**From:** Simon Davis  
**Sent:** 03 January 2018 15:59  
**To:** Planning Scanning  
**Subject:** FW: AL/129/17 Forge House

scale			date
1:100	@	A3	October 2017
job no	drawing no	rev	
16078	02.03	A

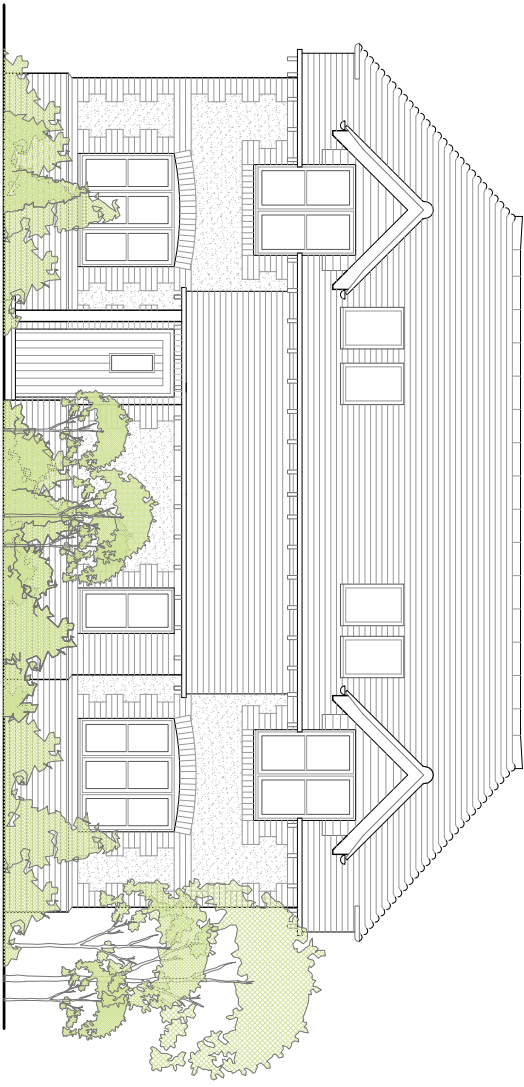
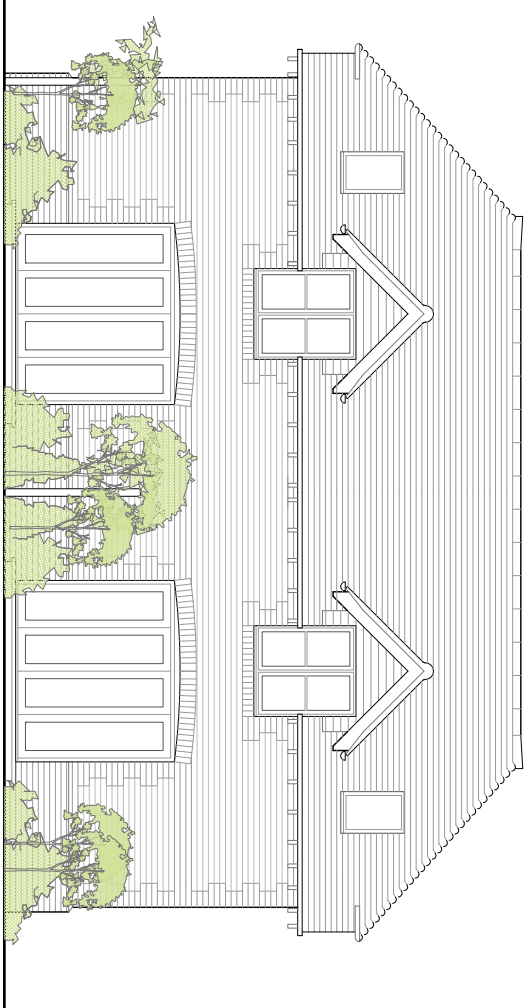
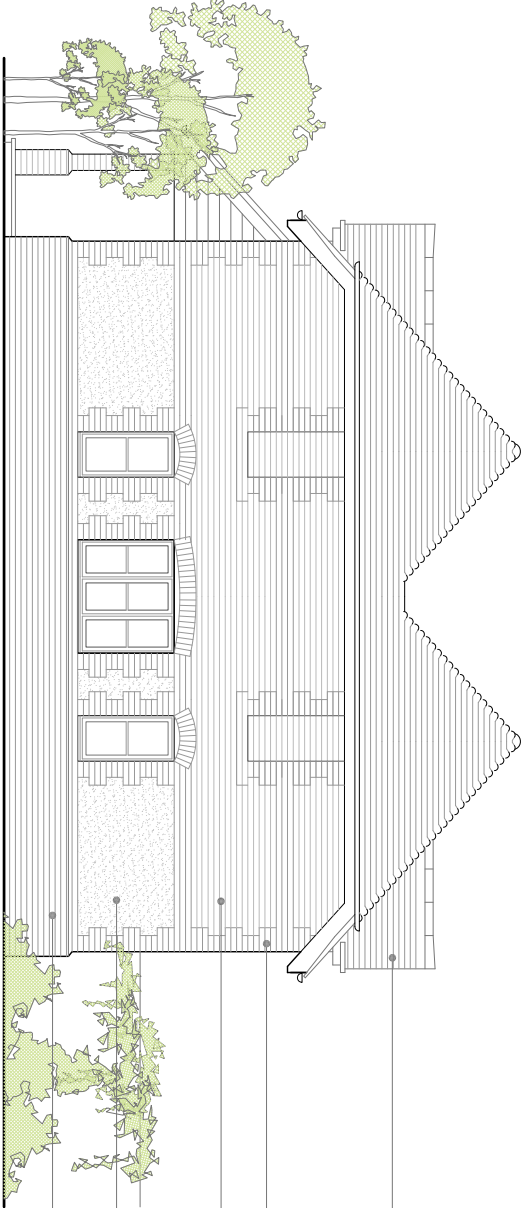
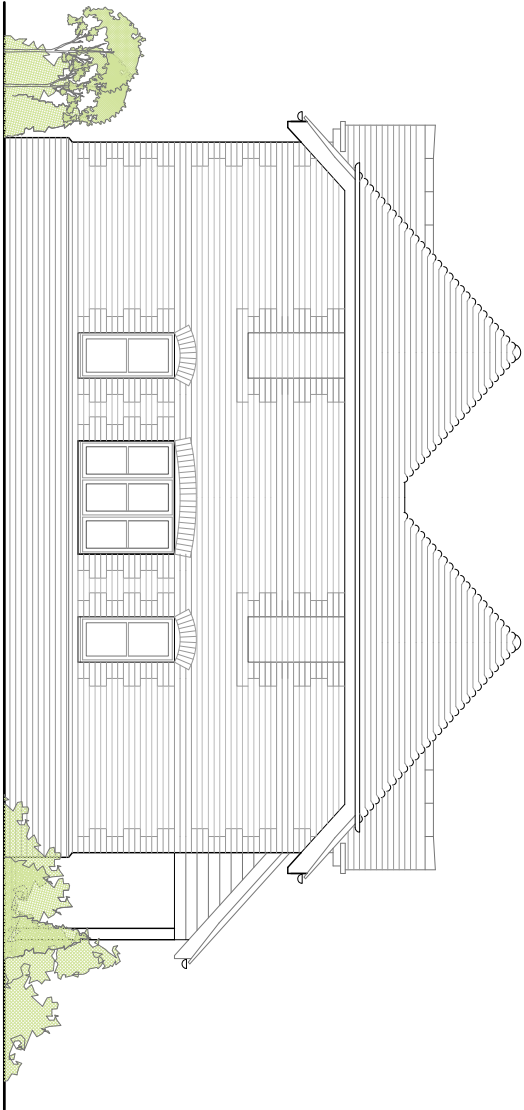
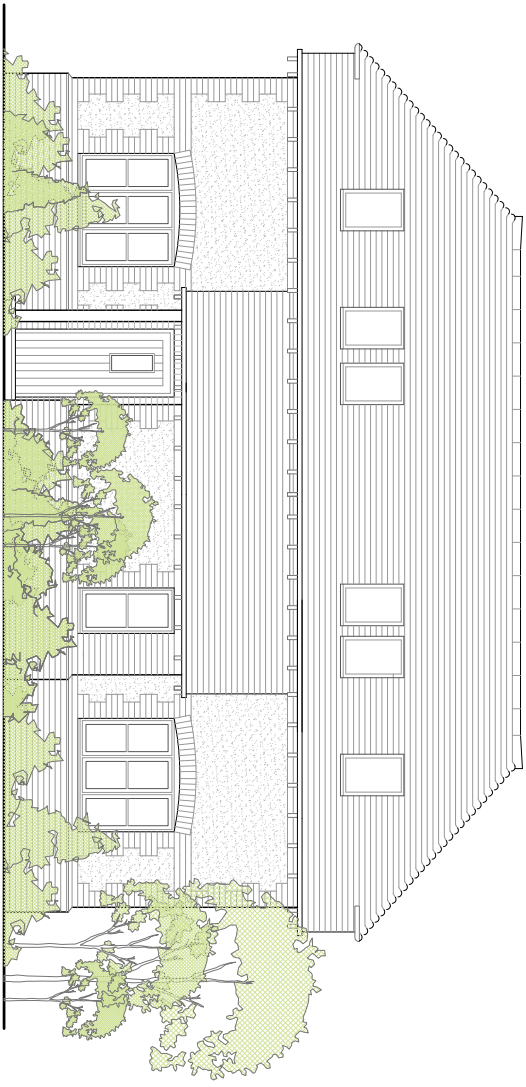
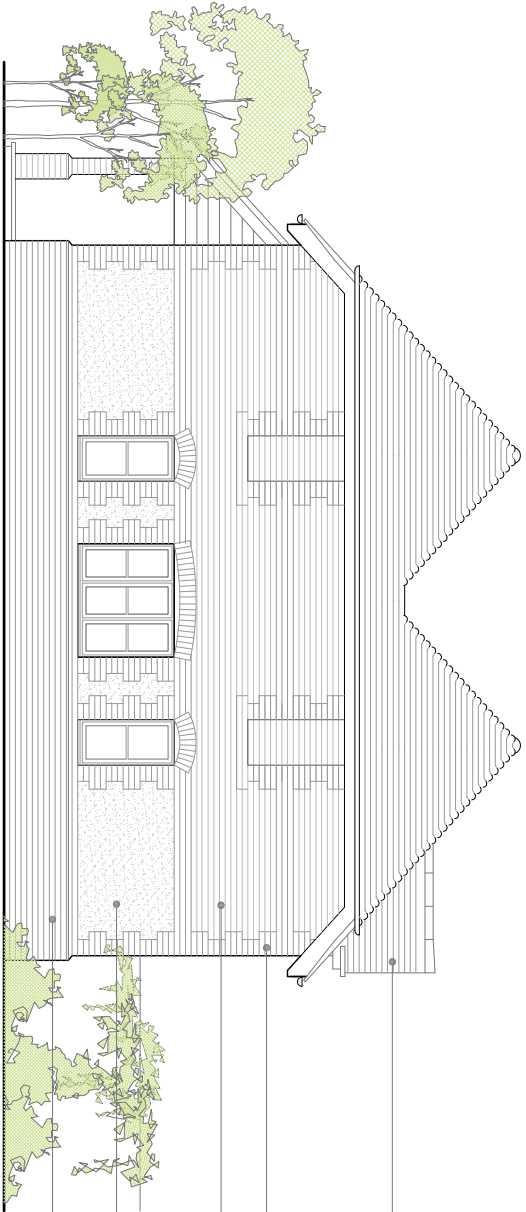
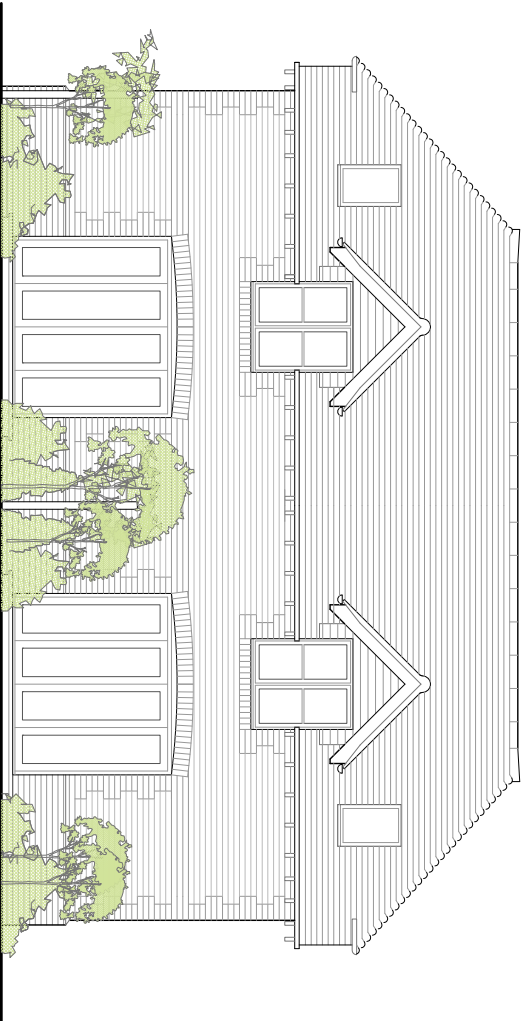
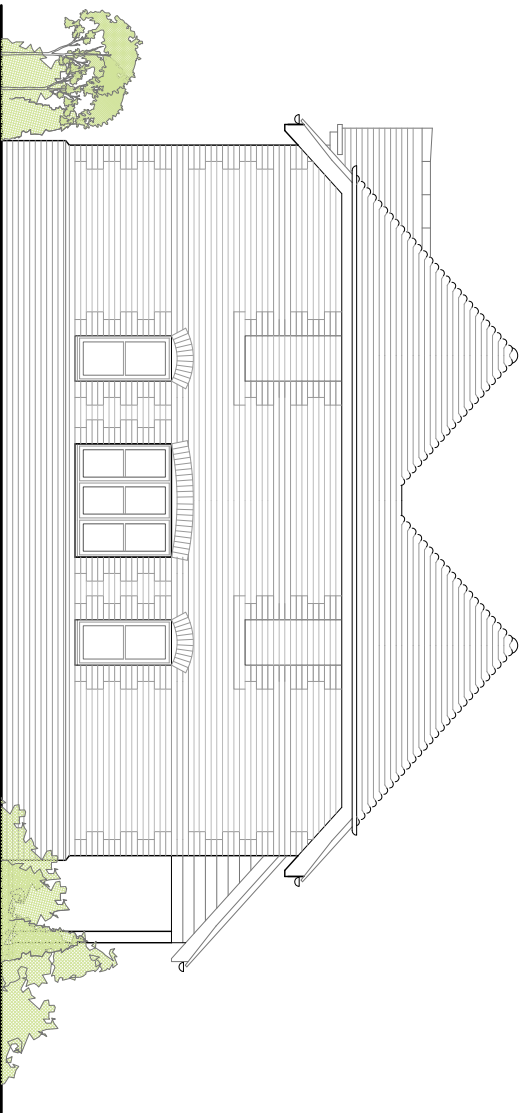
We have looked at the appearance within the street scape of the proposed new building and in accordance with the comments of the Design Officer, we are proposing to remove the front dormers to provide a less dominating roof scape. The revised plan will be with you as soon as possible.
